# TEXT\_M25J28\_ISH1\_Day2\_Session3\_040320 21

Client	MR L JONES & MRS K JONES			Scale	1:1000
	FOR APPROVAL				Drawn
Project	GROVE FARM ACCESS, JUNCTION 28 M25 NORTHBOUND SLIP LANE				
	ACCESS ALTERATIONS TO GROVE FARM				
Status	Sheet Size	A3	Date	JAN 2021	Rev
		Drawing No.	REDW-3396-110

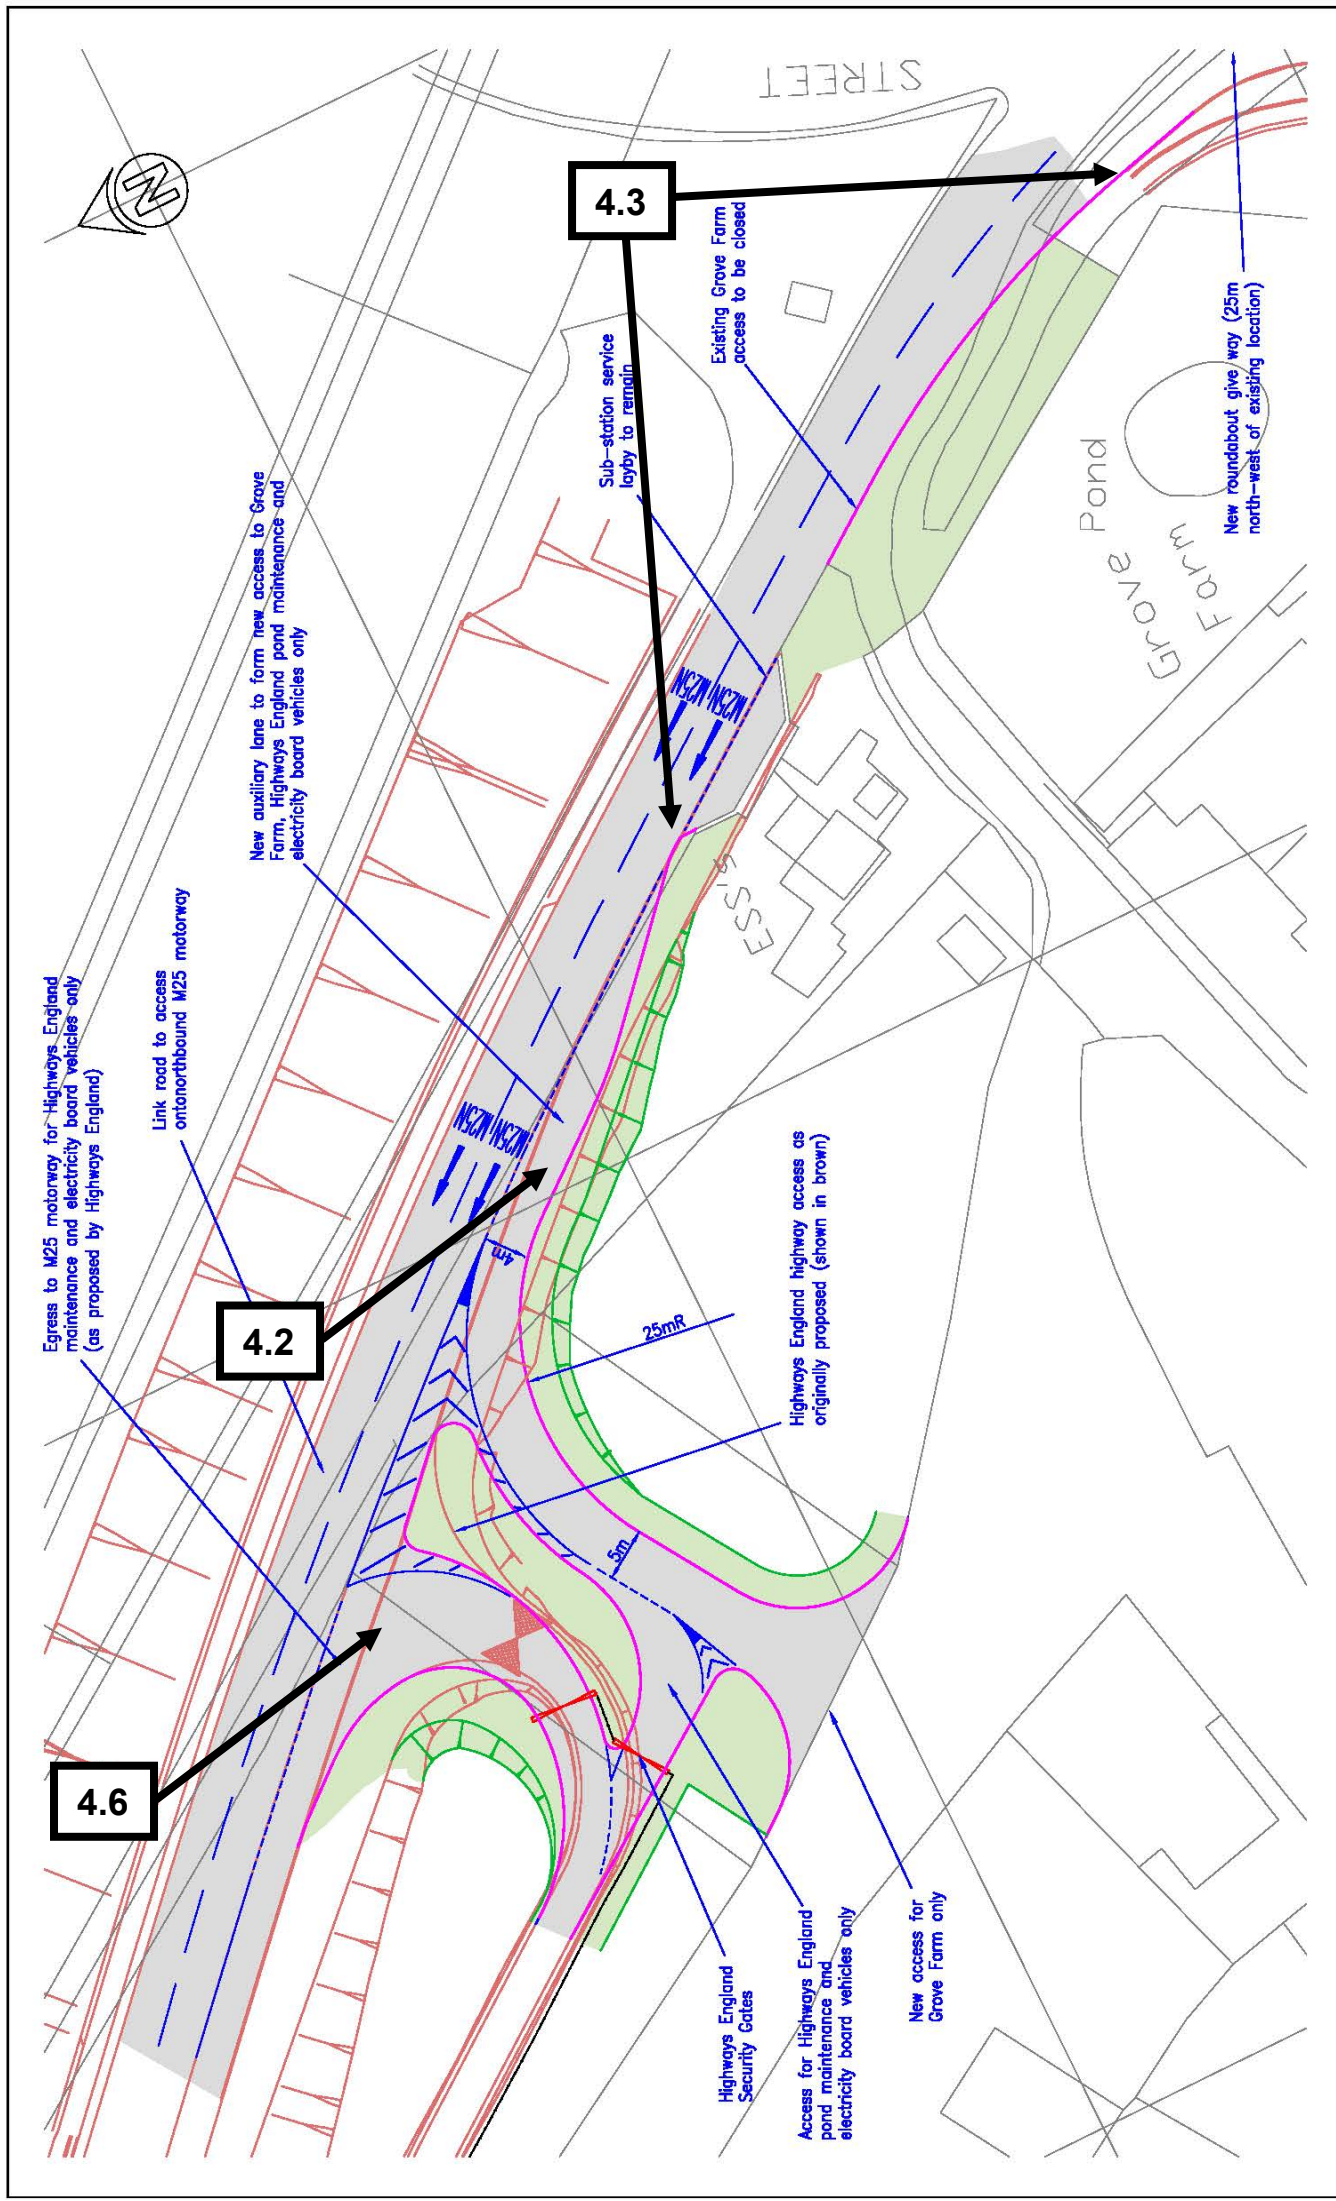
I'm going to be largely referring to Paul McLaughlin's plan 3396 110 If I may just hold that up to my screen. That is that is the plan there. I've highlighted in orange, the residential dwellings at grow farm in pink, is the embankment that's going to be built immediately to the rear of them

in grey, is the new slip road.

And in yellow, is the existing slip road. So that gives us a context as to the proximity of the works to their home,

you can probably see some sort of green Waleed cloud shaped things between the yellow and the grey.

And that is sort of existing tree planting, and flora and fauna, tall hedges and suchlike, which currently provide all the screening, that's necessary. So that that's the plan that I'm going to be going to be referred to going forwards.

if we can move the a 12, slip slightly to the west, he'd be happy to dispense with the access from the a 12 but obviously leave the egress onto the slip from the 12. But move that slip a bit further west so it moves away from his property, so that he's not immediately surrounded by that enormous pink embankment that I showed up a minute ago.

And those are shown on plan 396 110.
